Your Ref: OWPC18496
Our Ref: WA/26/18/OUT 22-03-2018
Please ask for:
Mr J Baeza

Outline application with all matters reserved for 6 No detached houses with detached garages. This application is a Departure from the Development Plan.

Former Lanes End House Adjacent to West Walberton Lane & Arundel Lane Walberton

Thank you for your internet representation made on 29th May 2018 which has been recorded as '**an objection**' with the comments as follows:

Former Lanes End - Six Six bedroom detached Houses with Garages Proposed Layout Scale 1:100 @ A3 (c) PJ Developments LTD 2018		REVISIONS		01
		MM/DD/YY	REMARKS	
	1	--/--/--	...	A
	2	--/--/--	...	
	3	--/--/--	...	
	4	--/--/--	...	
	5	--/--/--	...	
West Walberton Lane Proposal

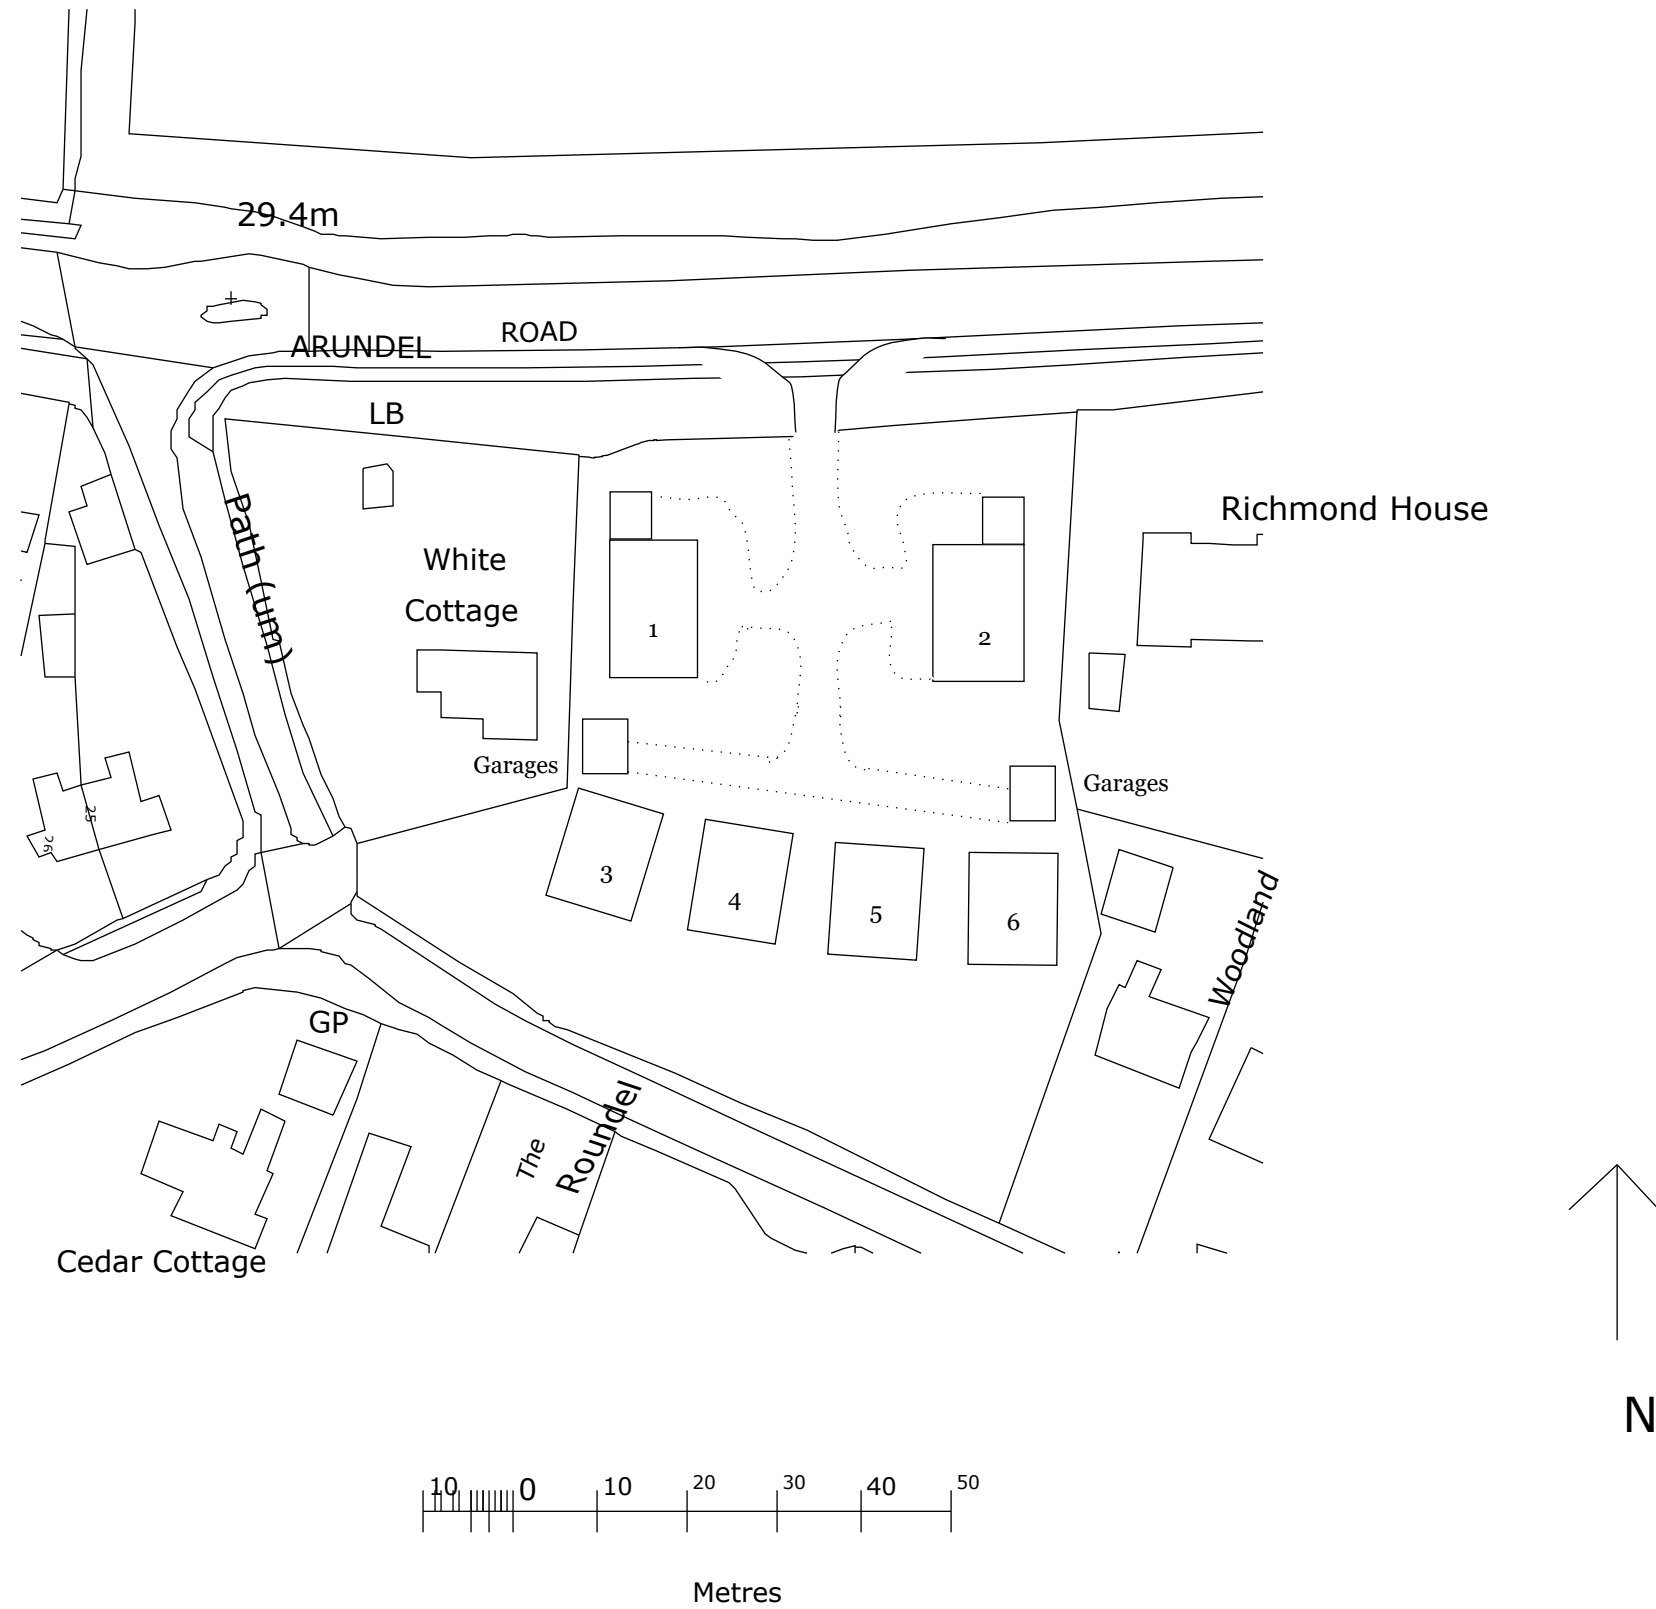
- 2. It is noted that the outline application is all matters reserved but it is worth mentioning that Units 1 and 2 in particular are very close to the neighbouring boundaries.*

- 3. Given the location of Units 1 and 2, overlooking will be a major concern especially when the proposals state that the houses will be three storey.*

- 4. The proposed houses given their height, size and area will be very dominating and uncharacteristic of the general area.*
- 5. The plot sizes are unlikely to be quite as large as suggested in the supporting statement given the area required for circulation and access. Units 1 and 2 in particular seem to have very small plots relative to the size of the house.*
